Application by Eggborough Power Limited for an order granting development consent for the Eggborough CCGT project

Eggborough Power Limited: Eggborough CCGT project order

Planning Inspectorate reference: **EN010081**

Environment Agency – written representations

Drawing Title
FIGURE 5.2: INDICATIVE GAS SUPPLY PIPELINE CONNECTION WORKS TYPICAL CROSS SECTION OF CONSTRUCTION CORRIDOR

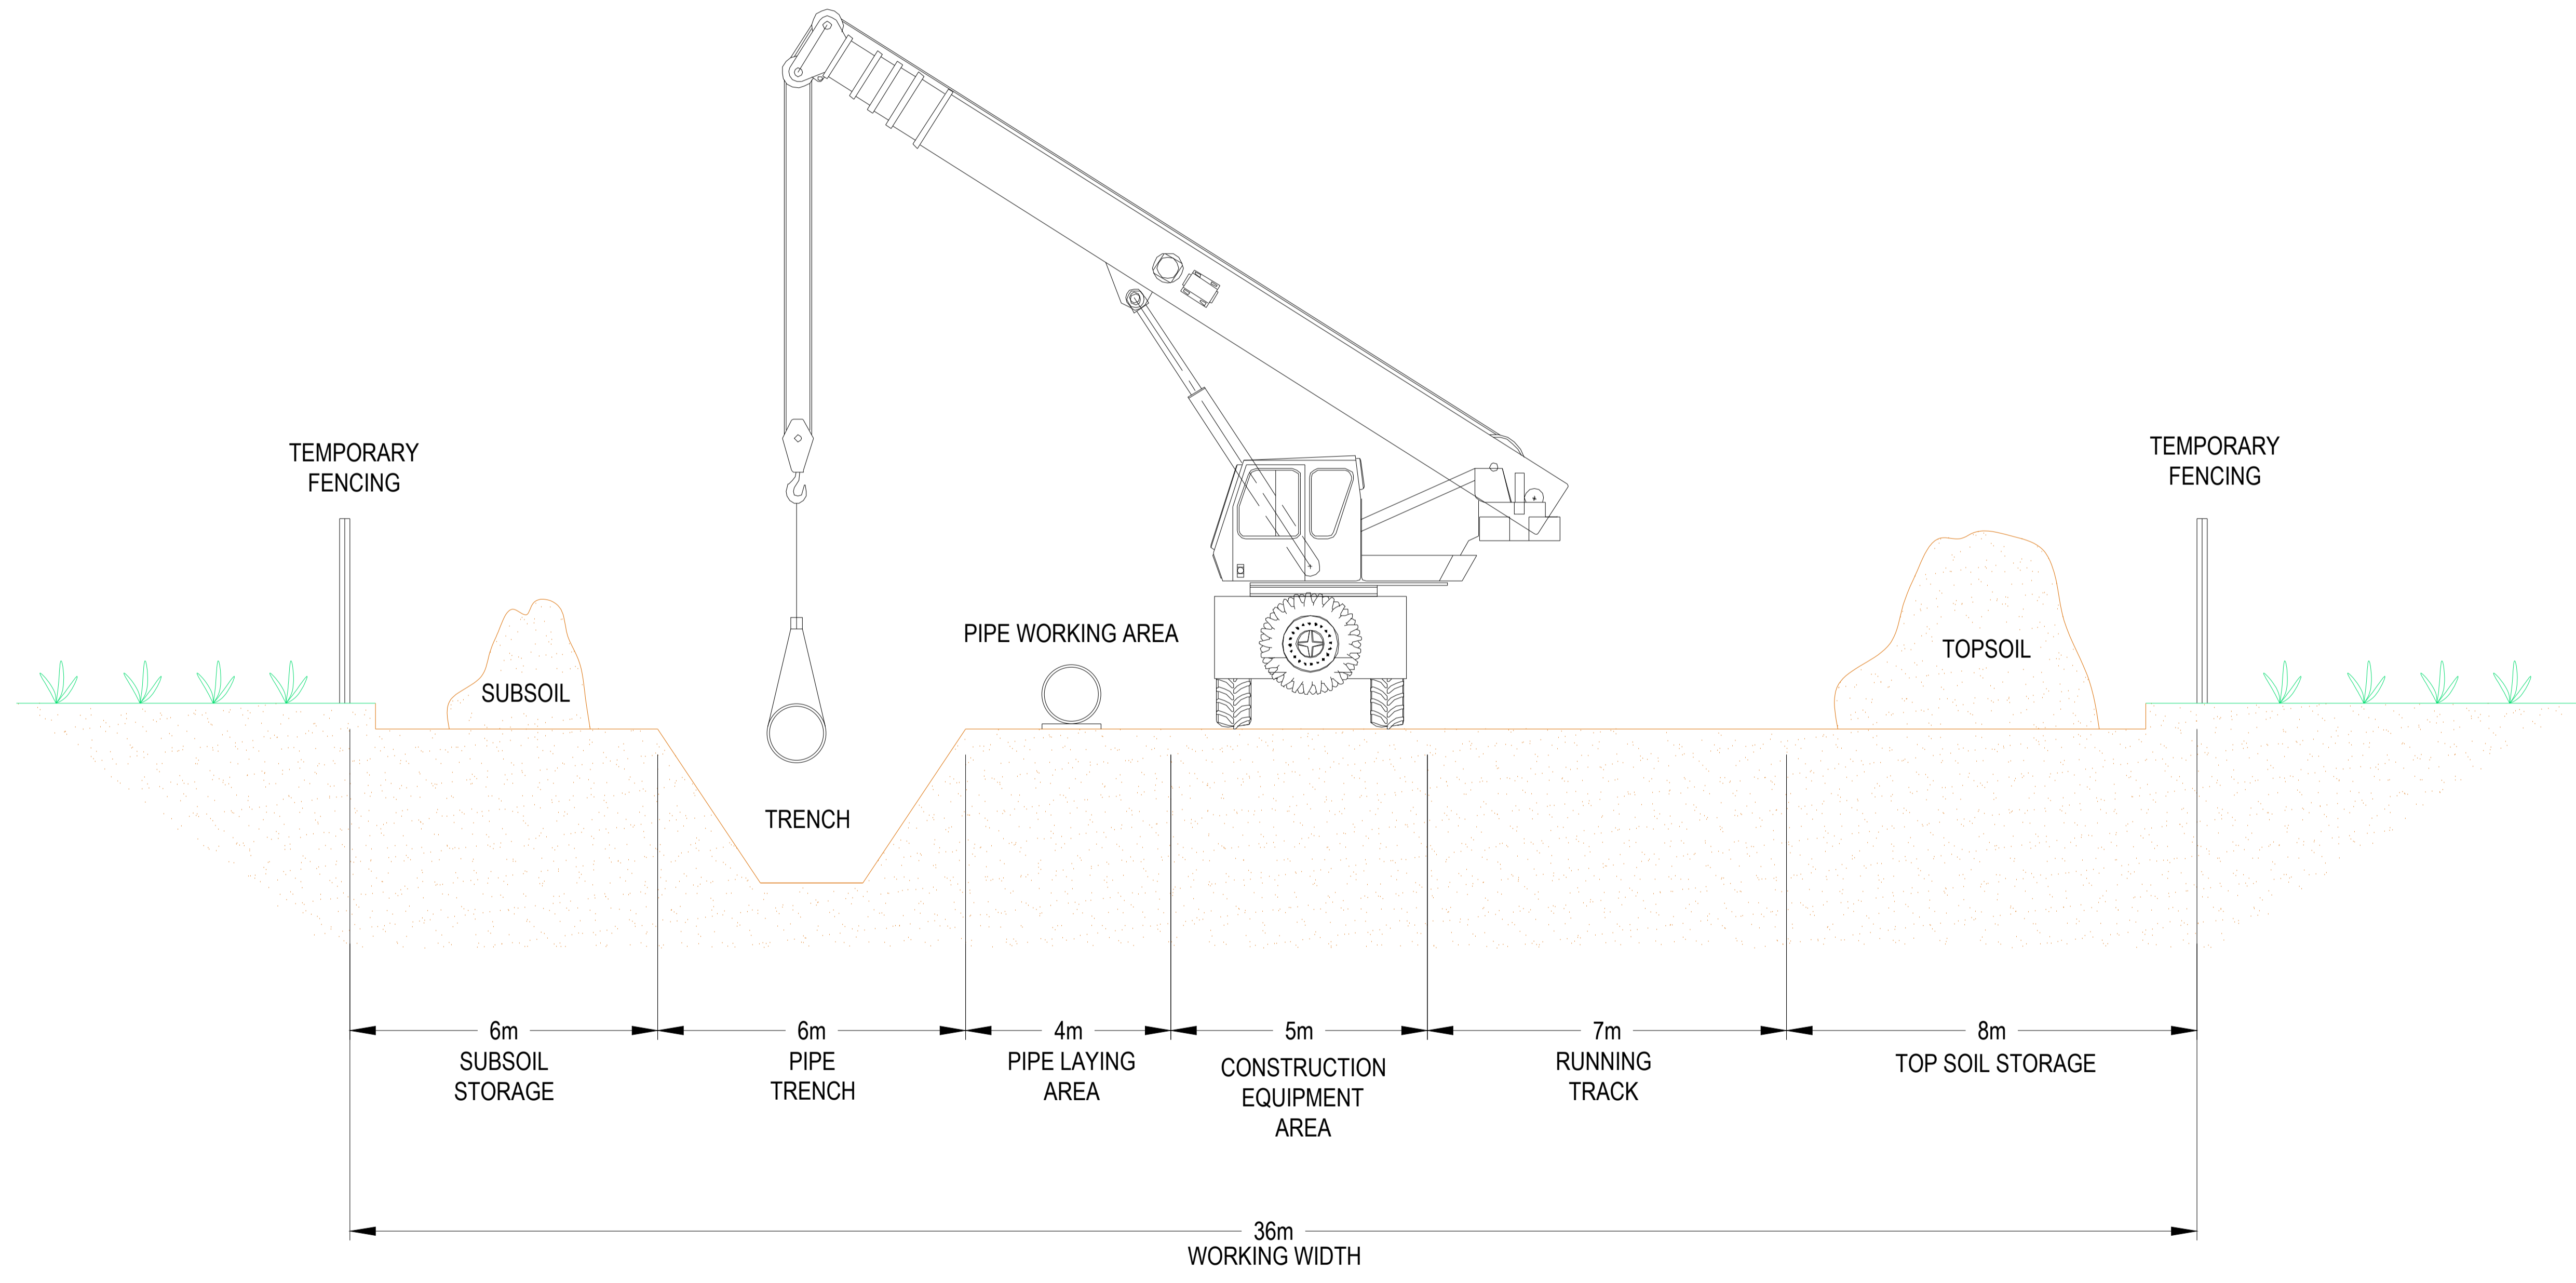
The Environment Agency (EA) in its Relevant Representation [RR-013] raises concerns that the open cut crossing either side of the River Aire will affect the integrity of the EA's flood defences on this land.

i) Explain how the crossing could affect flood defence integrity, and mitigation that would alleviate its concerns.

In response to our concerns, the applicant has since suggested that they use horizontal directional drilling instead of an open cut technique. This method is a preferable method of constructing the underground gas pipeline as it is less likely to affect our flood defences.

Despite this, we would like the DCO to provide some further safeguards to protect our defences' integrity. We are therefore in the process of drafting some wording for a requirement which will seek monitoring to be carried out for subsidence and, if needed, a mitigation scheme to deal with any settlement. We will update the statement of common ground to reflect any agreement reached.

INDICATIVE COFFERDAM ARRANGEMENT
(COOLING WATER DISCHARGE POINT)

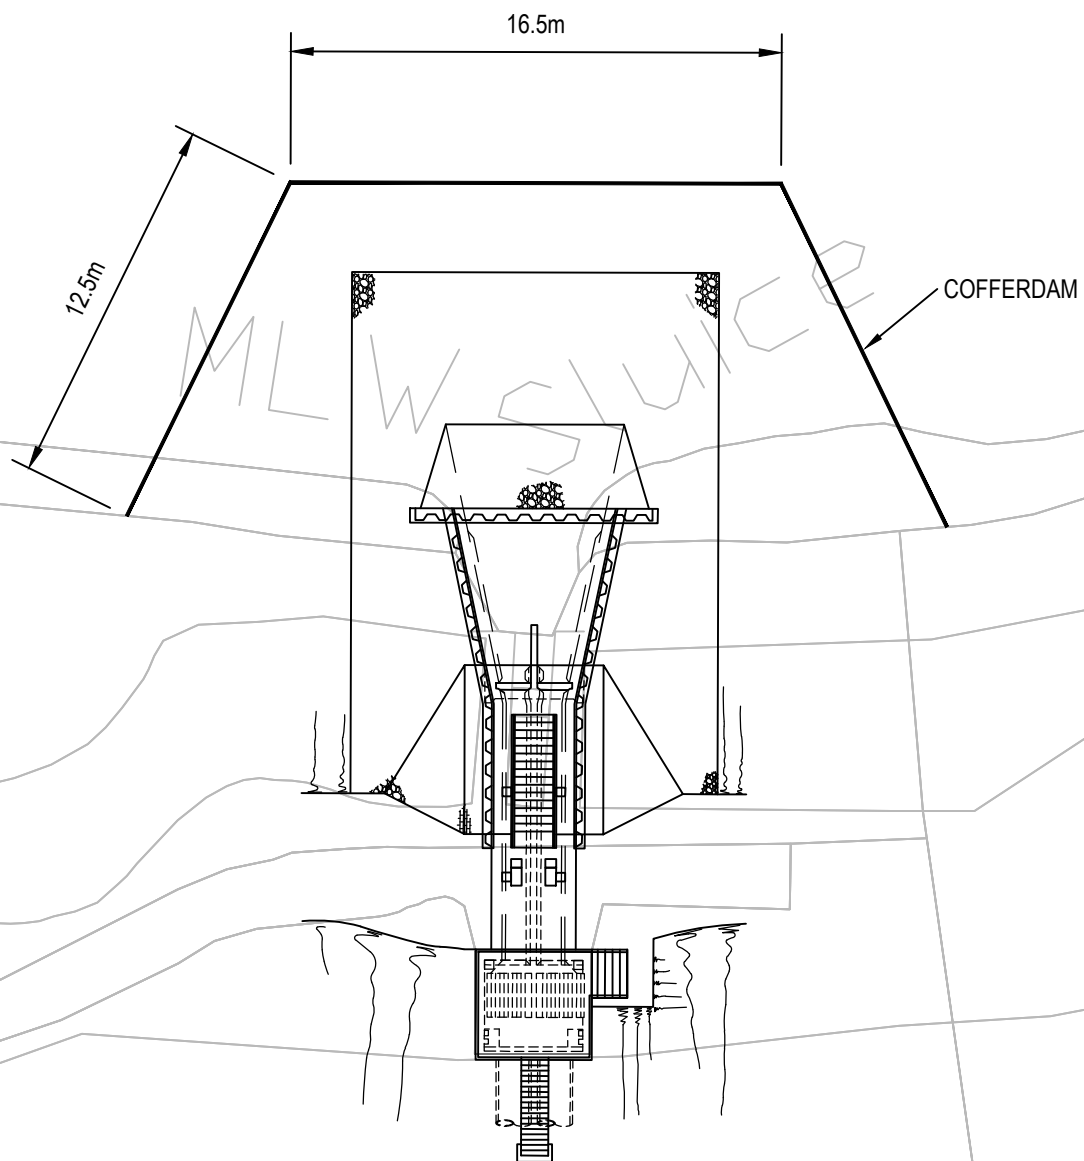
- i) Comment on the need for a specific plan for cofferdam removal.

Our environmental concerns associated with the process of removing the cofferdams relate to silt pollution and the potential for disturbing migratory fish. Requirement 18 (CEMP) includes a silt management plan and requirement 5 (detailed design) requests that we are consulted on the timing of the removal of the cofferdams at the intake and outfall points.

We therefore consider that there is no need for a specific plan for cofferdam removal given that any environmental concerns should be adequately addressed within the DCO.
